**From:** [Biazar, Shahab](#)  
**To:** [Ron Bohannan](#)  
**Cc:** [Amadeo Trujillo](#); [April Christie](#); [Planning Development Review Services](#); [Rodenbeck, Jay B.](#); [Armijo, Ernest M.](#); [Cherne, Curtis](#); [Wolfley, Jolene](#)  
**Subject:** Re: [#2023024] 2023024 Playa Del Sur Maimi Rd Noise Study (PR-2023-008674)  
**Date:** Monday, January 6, 2025 3:14:53 PM  
**Attachments:** [Outlook-cid\\_image0](#)

**From:** Donna Bohannan <djb@tierrawestllc.com>  
**Sent:** Monday, January 6, 2025 11:01 AM  
**To:** Planning Development Review Services <PLNDRS@cabq.gov>; Biazar, Shahab <sbiazar@cabq.gov>; Rodenbeck, Jay B. <jrodenbeck@cabq.gov>  
**Cc:** Ron Bohannan <rrb@tierrawestllc.com>; Amadeo Trujillo <ATrujillo@tierrawestllc.com>; April Christie <achristie@tierrawestllc.com>  
**Subject:** [#2023024] 2023024 Playa Del Sur Maimi Rd Noise Study (PR-2023-008674)

Figure 2 - Upwind vs Downwind Decibel Reduction

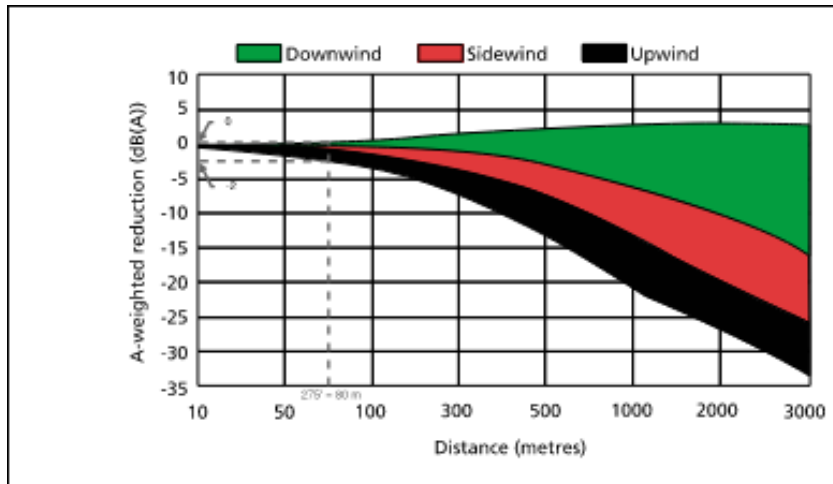
The numbers look good. The only question I had was on the 2 decibel reduction read from Figure 2. Just wanted to confirm that this is an allowed reduction under the noise study.
